Please upload onto Ocella the following email which is an additional consultation response from the Local Highway Authority to planning application **A/76/20/PL** – regarding Land at Dappers Lane, Angmering.

Rob / Michael.

Planning Layout - 84 Units

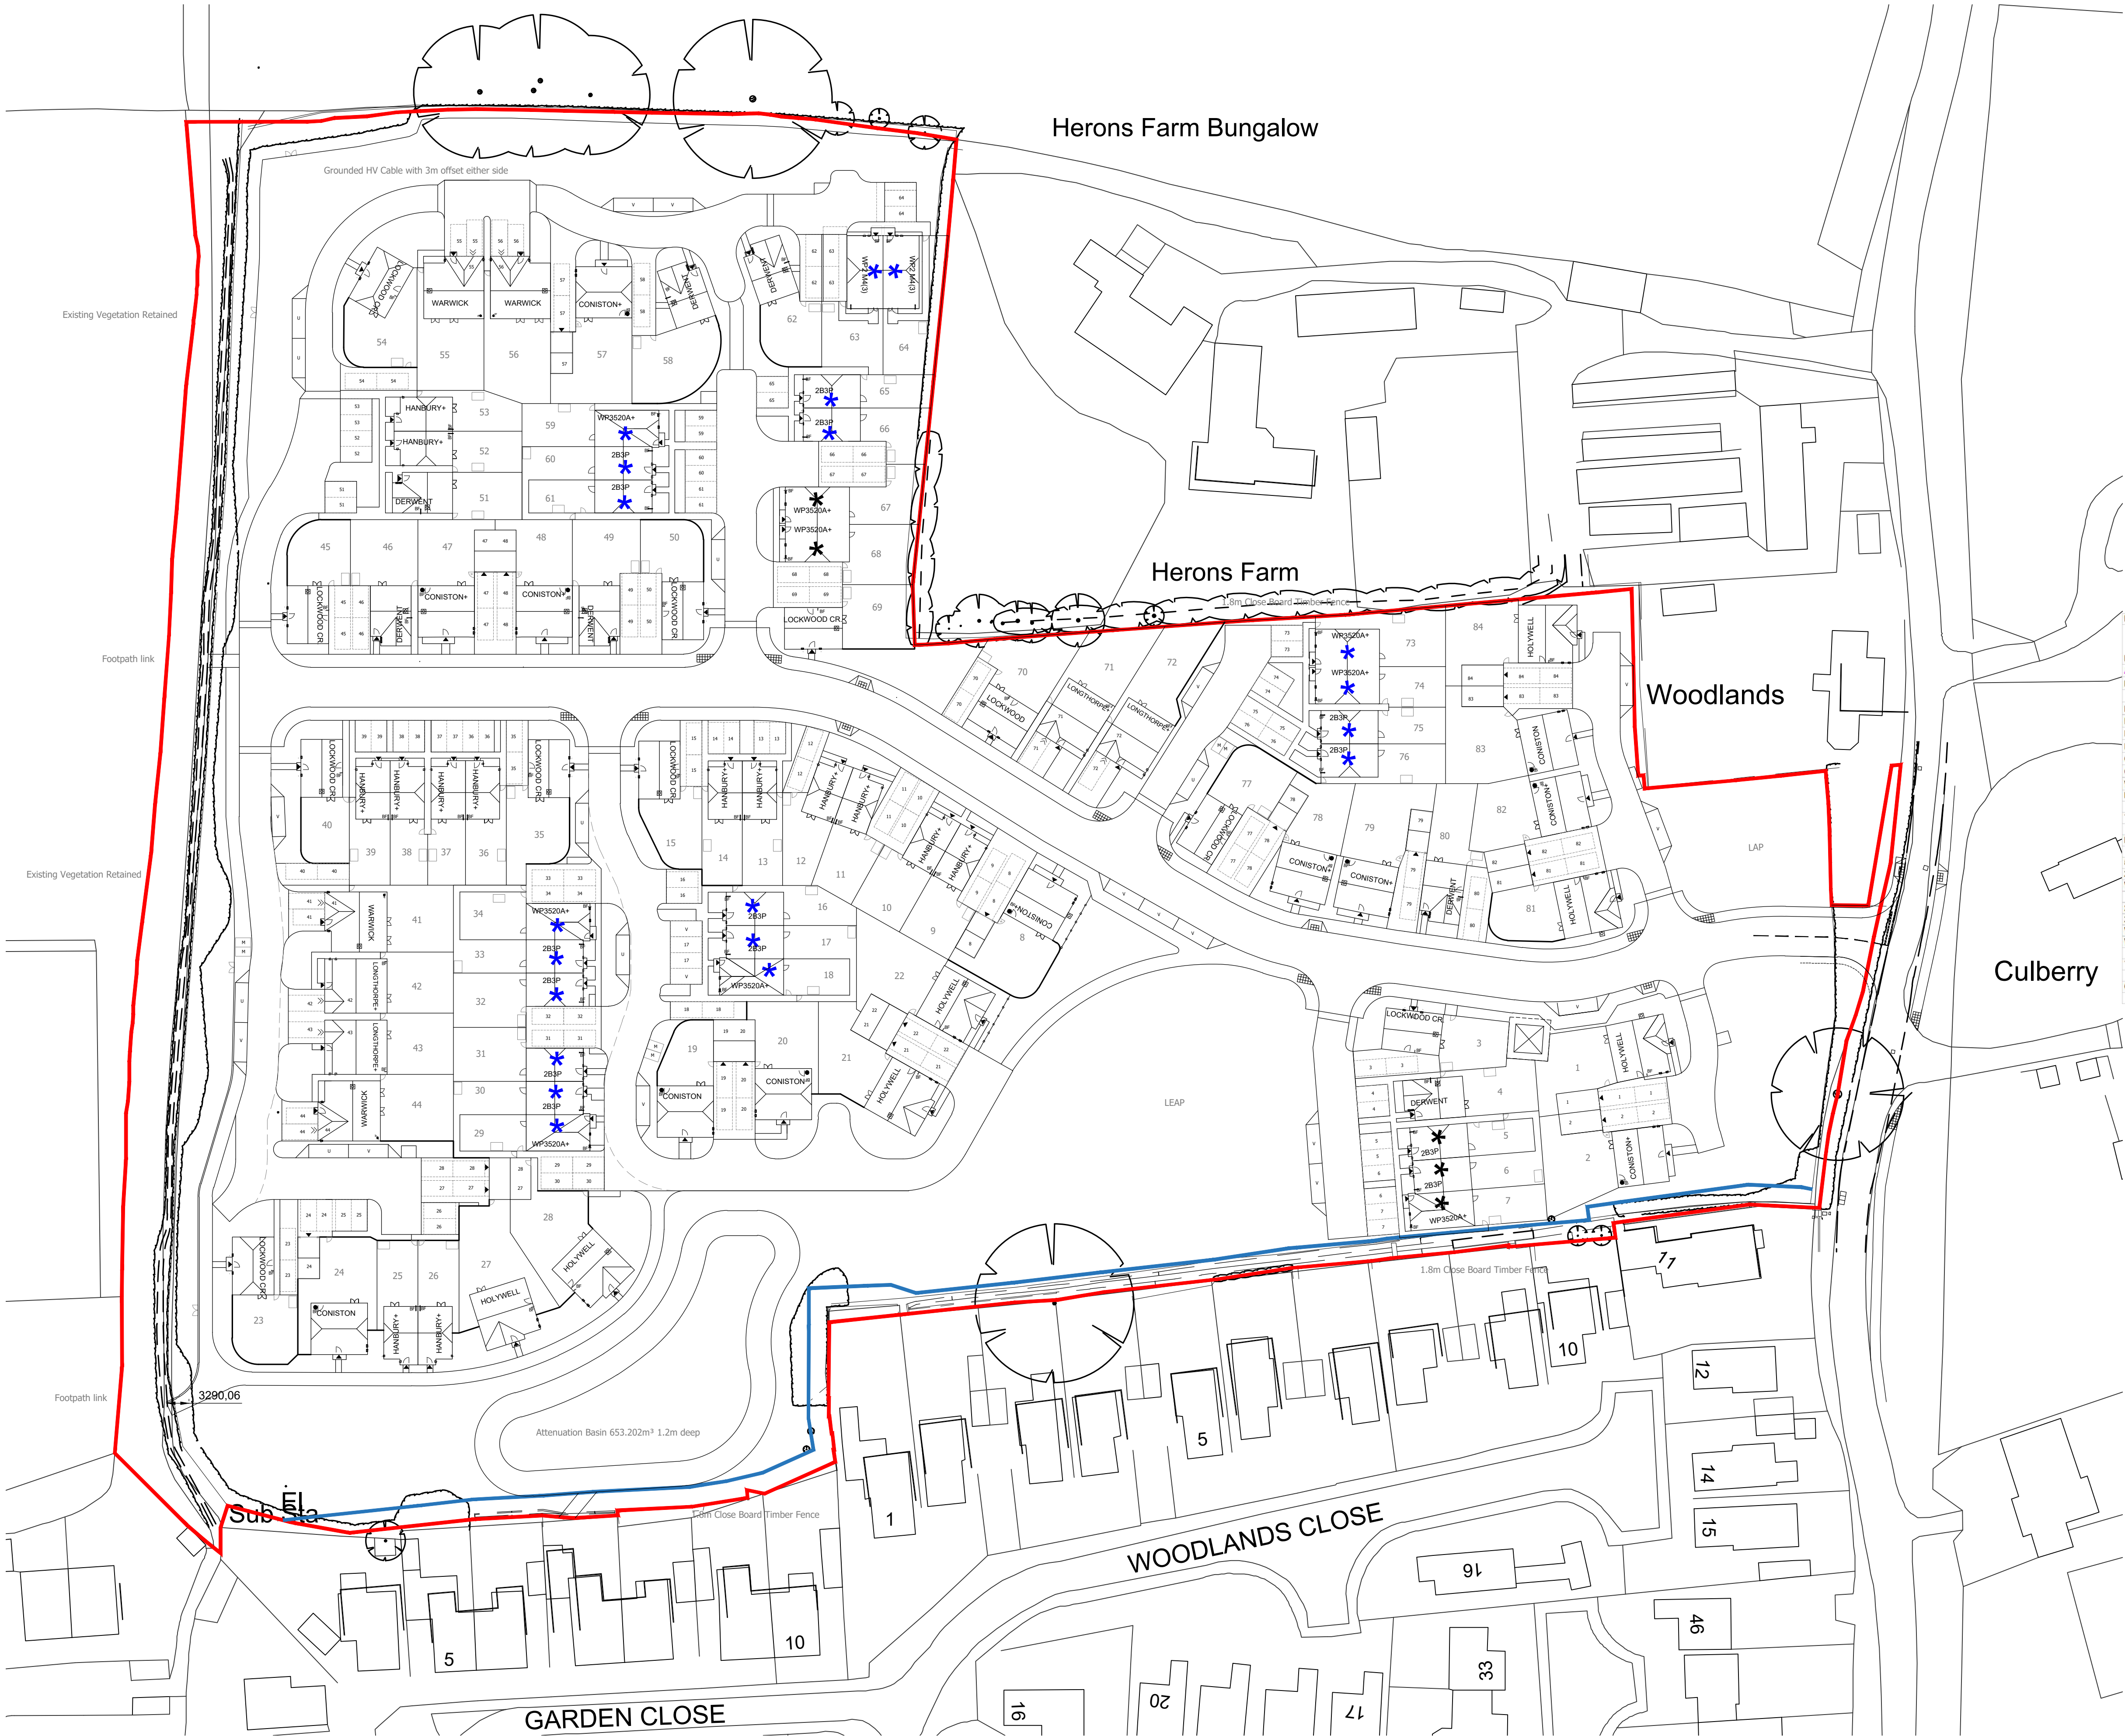
I note that 27 of the parking spaces counted are garages and as such would only count as 0.5 spaces within the Arun SPD. Reducing the overall total by 14, Given the increase in visitor spaces and the provision of the travel plan then no highways issues are raised.

No dwelling shall be first occupied until the car parking serving the respective dwelling has been constructed in accordance with the approved site plan. Once provided the spaces shall thereafter be retained at all times for their designated purpose.

Following the consultee response from Stephen, I wanted to confirm that our proposals are in accordance with the Arun Parking standards. Moreover, we are over providing on unallocated/ visitor spaces as we only need to provide 20% visitor spaces (17 versus 25 we’re currently providing). This site sits within Parking Behaviour Zone 2, so generally speaking, we need to provide either 2 or 3 spaces per dwelling.

Finally, in regards to the EV charging points, please find attached the proposed layout demonstrating 50 EV charging points, agreed previously. Briefly, every house with a garage plus driveway will have an electric charging point, plus (ii) houses without a garage equates to 23 EV charging points...this is based on 114 spaces x 20% = 23 (for the remaining total car parking spaces).
